Application Reference: 2025/0673

Site Address: 73 Laithes Lane, Athersley South, Barnsley, S71 3AQ

Introduction: Erection of front porch extension to dwelling (Retrospective)

PROPOSED FRONT ELEVATION

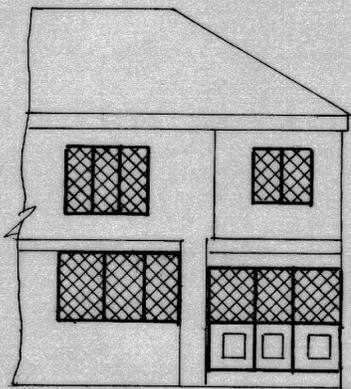
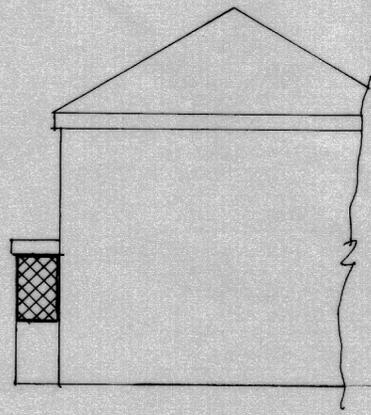
The forward projection of 1.9 metres is considered modest in the context of the site. The front elevation also provides a bay window with an approximate 1 metres projection which lessens the impact of the front porch. The use of a low-pitched lean-to roof is tantamount to a flat roof and not normally permitted, however given the dwelling features a flat roofed bay window along with other dwelling on the street scene, the use of a low-pitched lean-to roof is considered acceptable and in keeping with the site and street scene on this occasion.

The use of brown PVC does match the windows on the dwelling, however along with the polycarbonate roof materials, provides a design similar to a conservatory, which would not usually be acceptable.

Given the site is significantly set back from the main highway due to the intervening grass verge, the proposal has a reduced dominance on the street scene.

PROPOSED SIDE ELEVATION

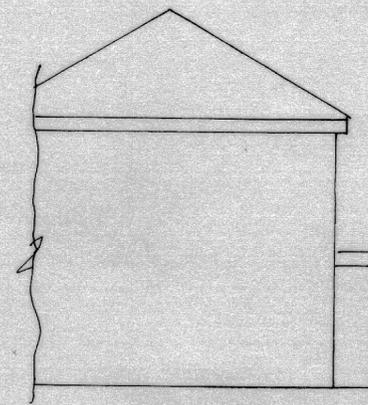
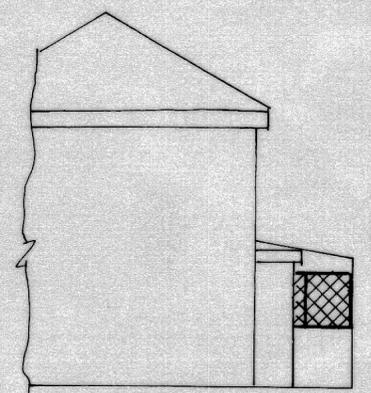
The porch is sited to the west of adjoined 75 Laithes Lane. The porch provides a modest projection and is reduced in its impact to 0.9 metres by the projecting bay window. The height of the porch is less than the existing bay window and is therefore not impactful on adjoined 75 Laithes Lane. The site is significantly set back from and also set at a lower floor level than 71 Laithes Lane to the west, removing any impact the porch would have on this neighbour.
